From: Anita Gardner
Sent: 29 November 2018 14:40
To: Planning.Responses
Subject: FW: FG/159/18/PL Bluebird Cafe
Attachments: 2002 revision 02.pdf

From: Nina Sidhu
Sent: 06 November 2018 14:38
To: Planning.Responses
Cc: Anita Gardner
Subject: FG/159/18/PL Bluebird Cafe

01  
2002  
PROPOSED GROUND FLOOR PLAN  
Scale: 1:100

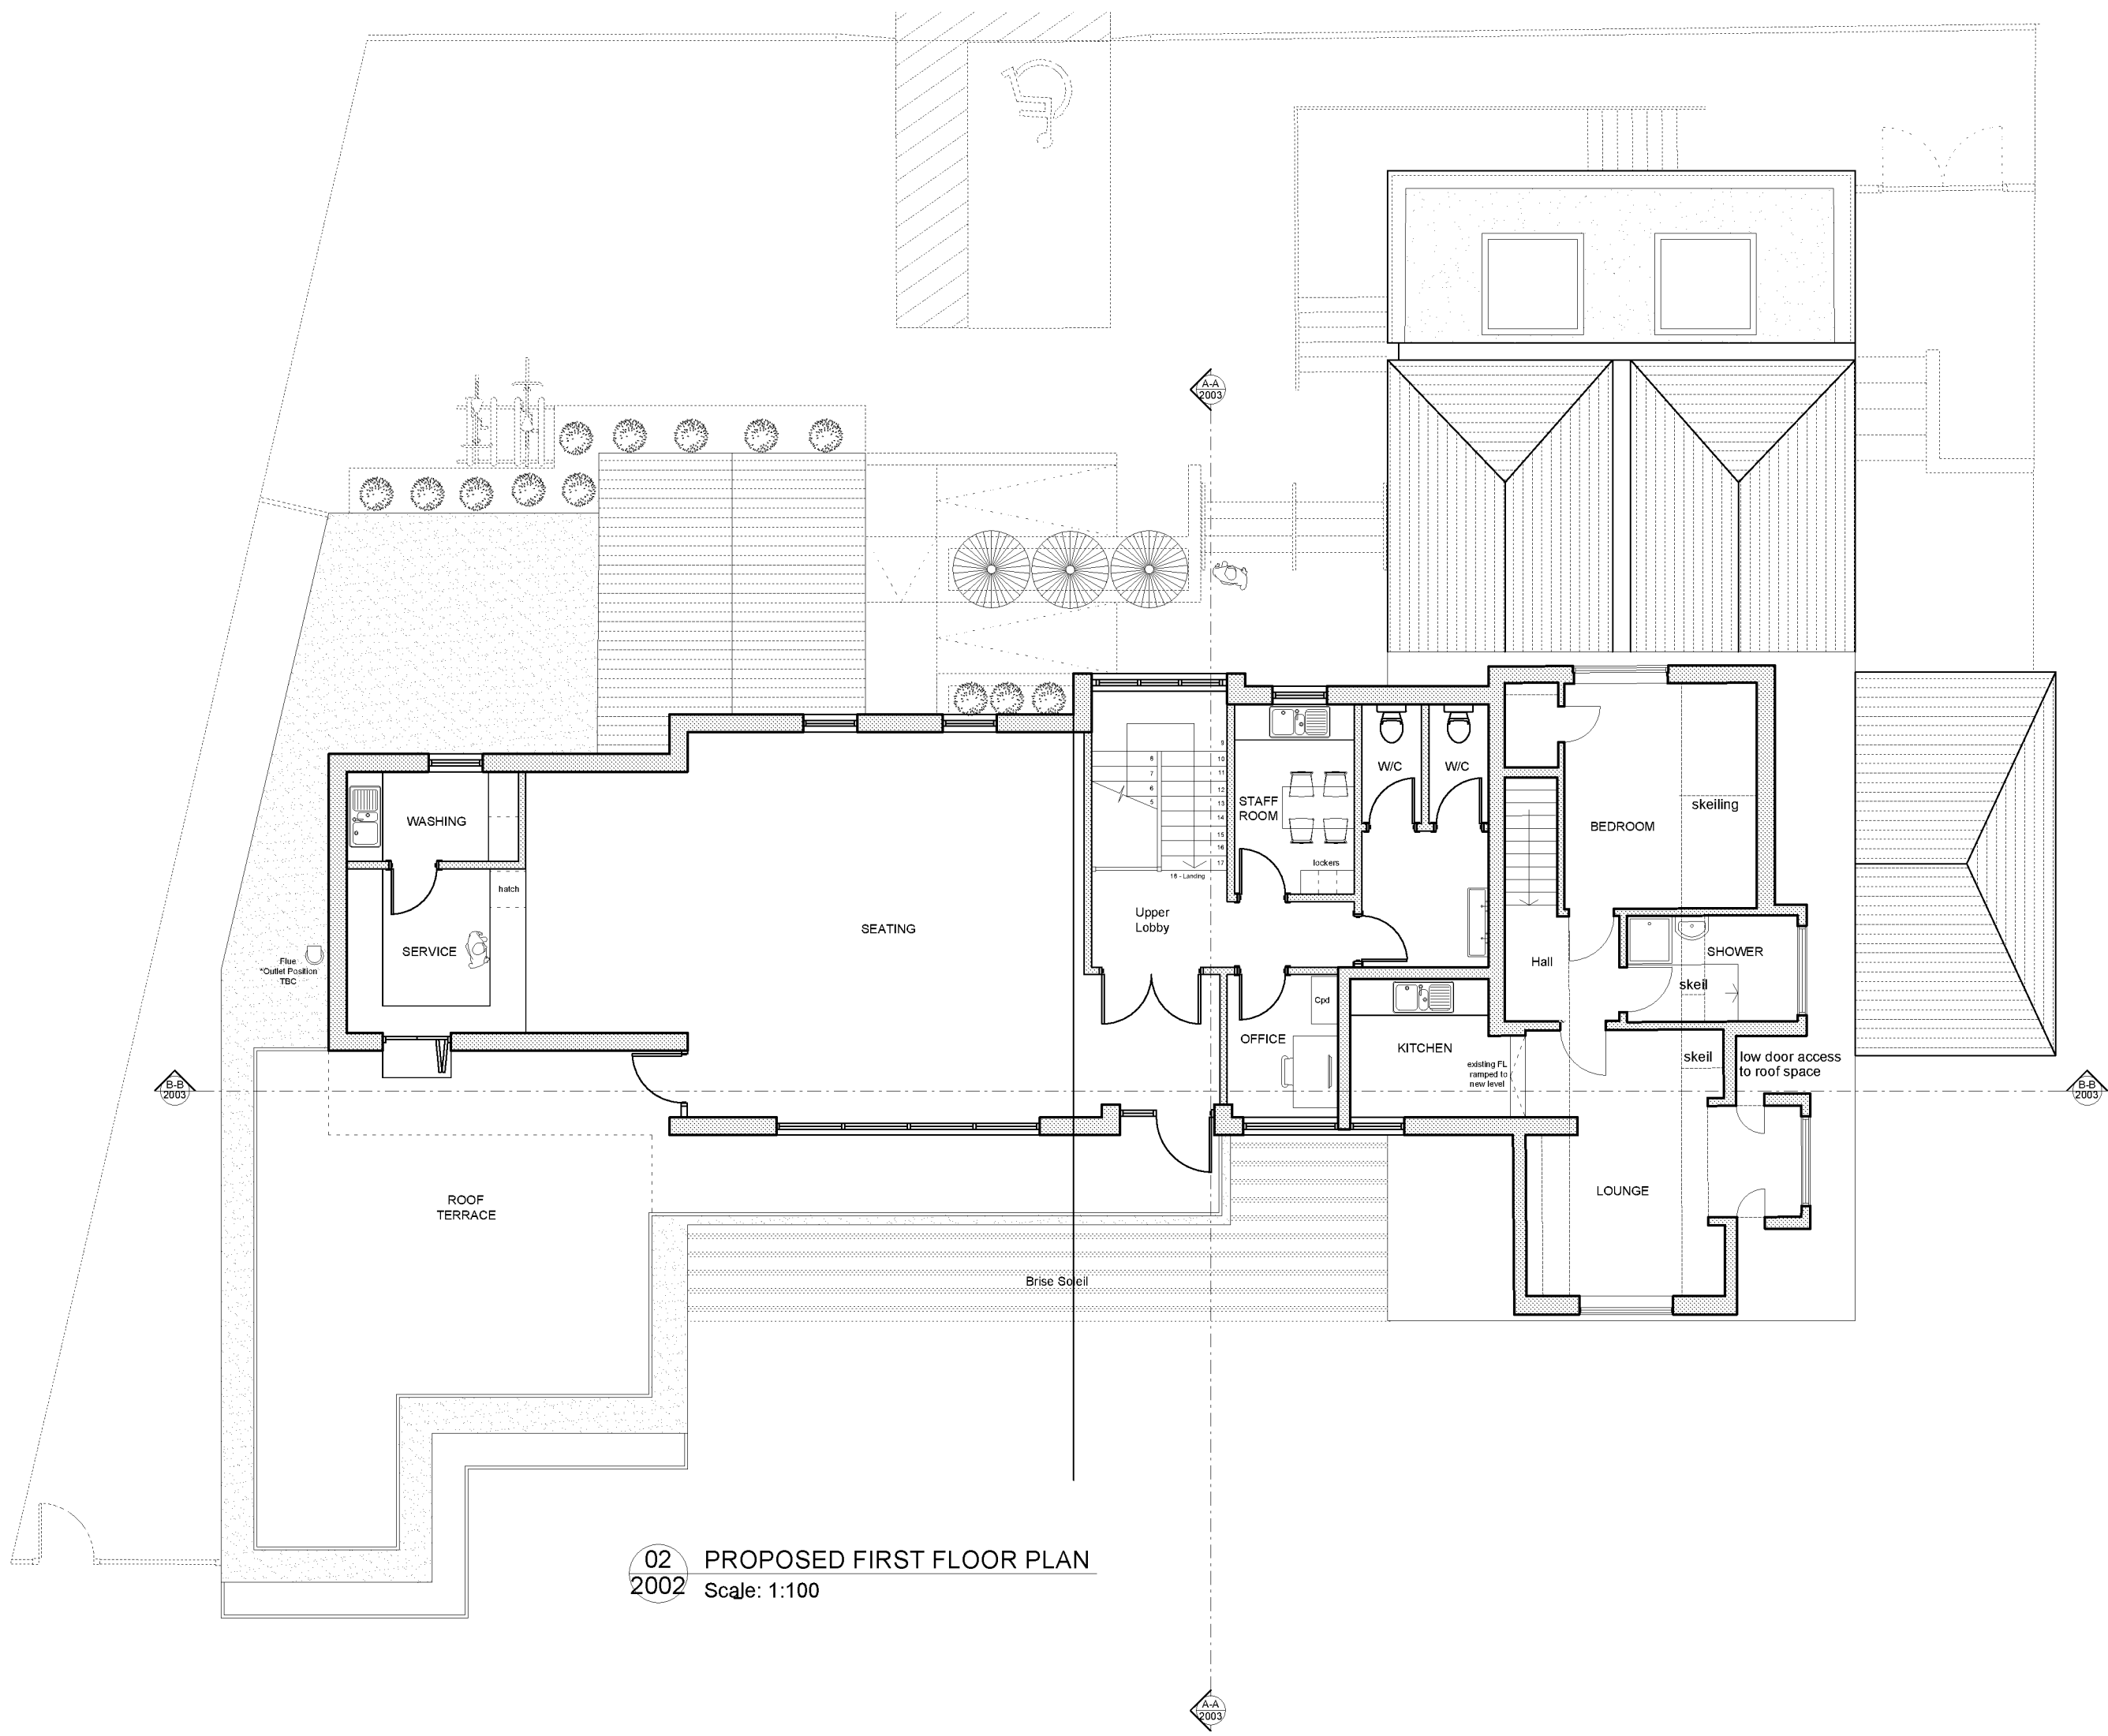
1. I am unclear as the exact number of covers proposed. Is the total number of covers 235? There is slightly conflicting information in the application documents and I would just like to clarify the exact numbers.

2. Sanitary provision: If the total number of covers is 235 the sanitary provision is insufficient and staff do not appear to have been considered. Please refer to Arun's Sanitary Provision Requirements document:
[REDACTED]

In relation to the comments from the EHO, I herewith provide you with a copy of an amended layout plan with revised WC provision.

With regard to the number of covers, the submitted drawings show a total of 216 as proposed (80 external + 136 internal). This is illustrated on the diagram within the DAS.

04 PROPOSED SOUTH ELEVATION  
2003 Scale: 1:100

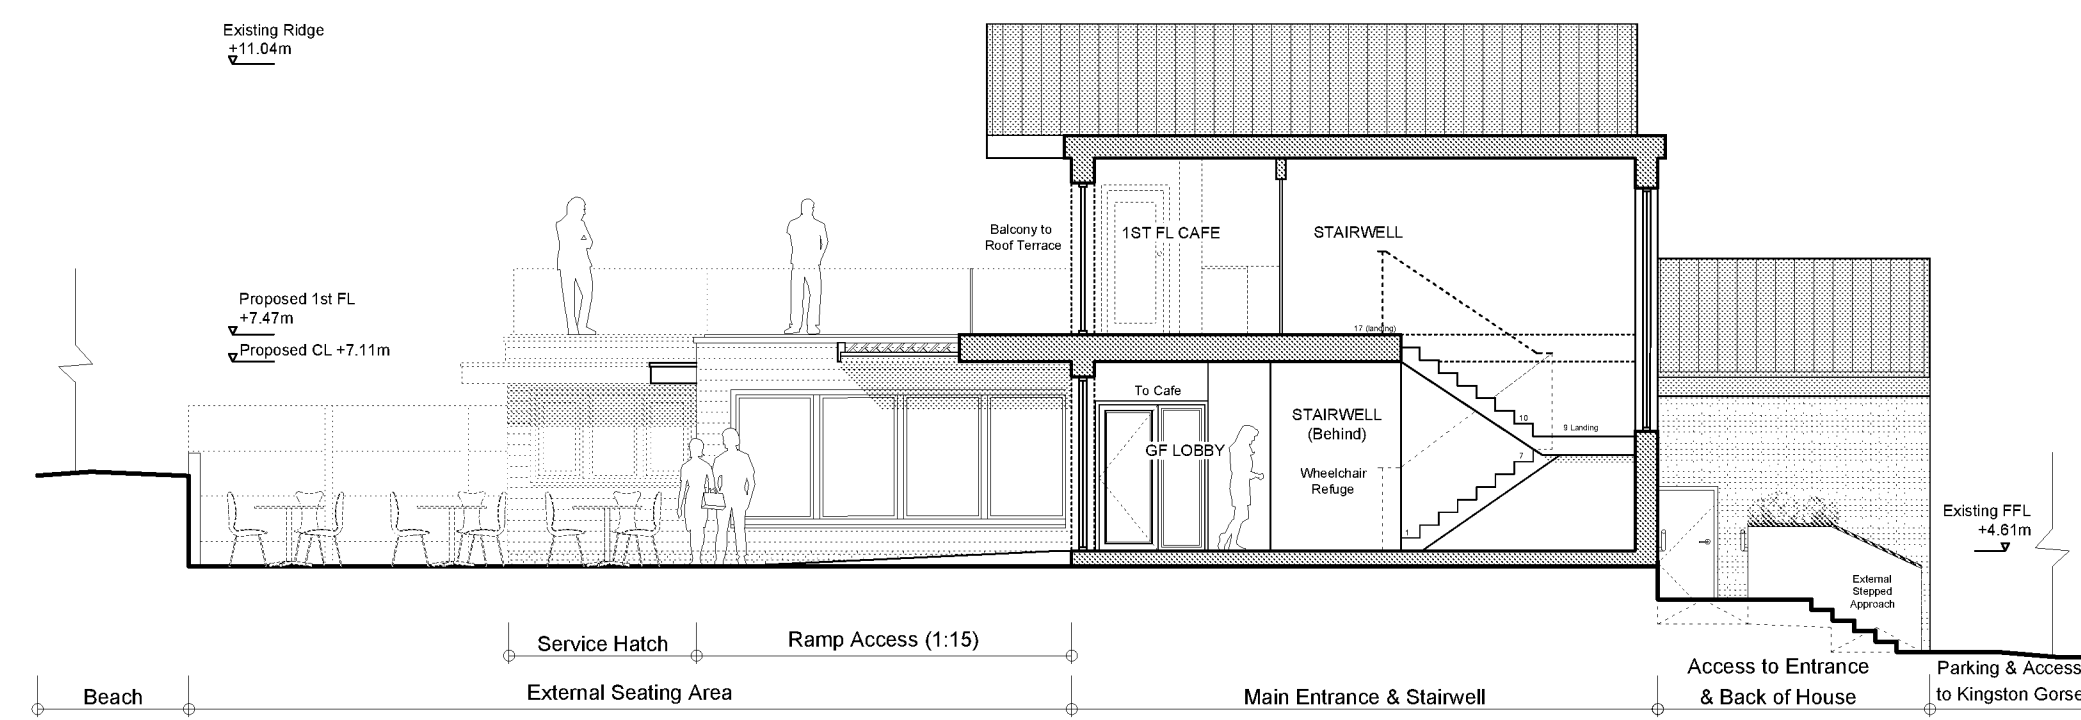
It would also be appreciated if a street scene could be submitted from the beach frontage .

Lastly, in respect of the beach scene elevation, I can confirm that the Applicant is undertaking further survey work, and once this has been received (in around 10 days' time), the architect will prepare the final drawing and we can then issue to you. Please can you confirm that these timeframes are acceptable to you?
